Flood Management & Drainage Consultation

Consultation on Application Number: 2016/92812

Address: Victoria Works, Fisher Green, Honley, Holmfirth, HD9 6DP

Proposal: Demolition of industrial building and erection of 17 No. apartments with integral garages and associated parking

Drainage Layout

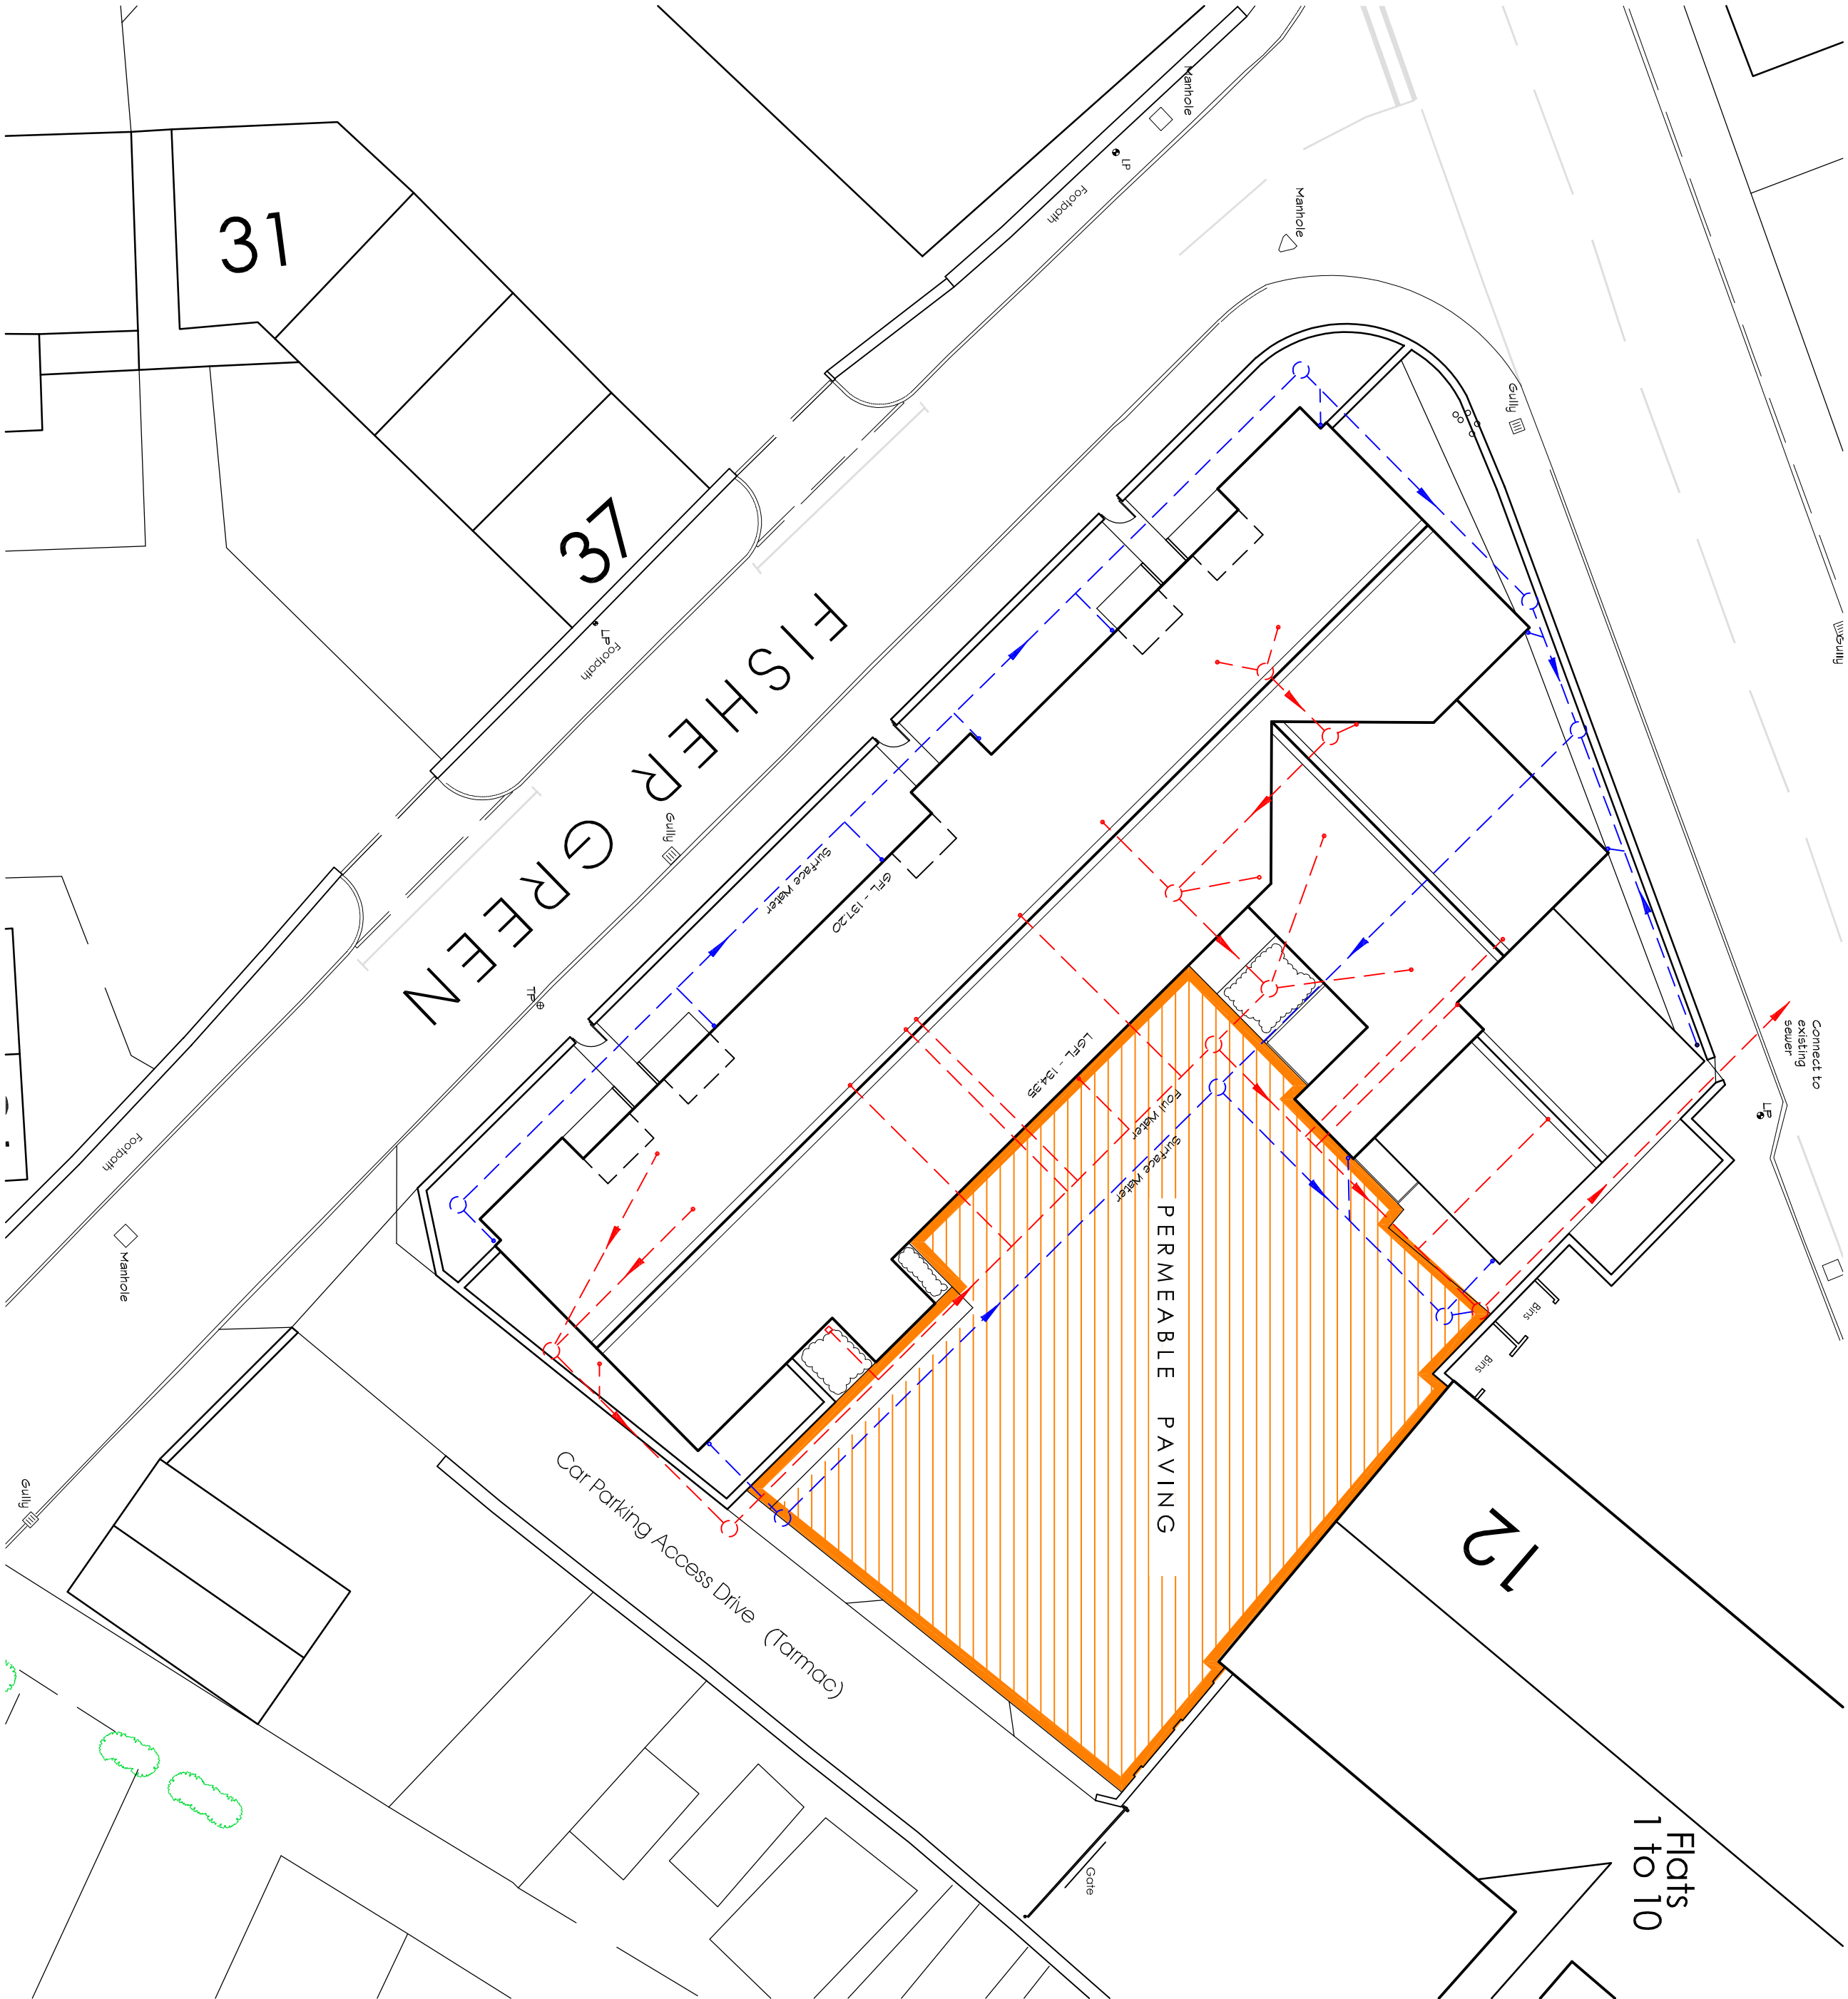
- Application not submitted in accordance with West Yorkshire Combined Authority SUDS guide.
- Promotion of permeable paving without testing and ignoring sustainable approaches for the remainder of the site.

An exploration of infiltration techniques should be submitted early in the application process. This has not happened. It is unclear therefore that permeable paving promoted is viable. If it does work we would expect infiltration techniques to be used throughout with no connection to sewer permitted. A connection to sewer is shown on a separate drawing. This is rejected until further supporting information is supplied.

If infiltration techniques are proved not to work in this area or create a risk then watercourse needs to be considered prior to sewer. Watercourses are available close to the site.

BGS data indicated infiltration techniques have very significant constraints, moderate susceptibility to groundwater contaminants, and relatively shallow groundwater, Local properties adjacent to the site are likely to have cellars which can be at risk to flooding where groundwater flows are introduced.

A full survey of existing drainage needs to be carried out to examine where surface water currently goes. It is noted that some yard areas are not positively drained on site and should be discounted from this assessment. Where connectivity cannot be proved a greenfield run off restriction should apply. Attenuation is likely and the planning officer needs to be assured it can be accommodated on site within the proposed layout. This also has not occurred.
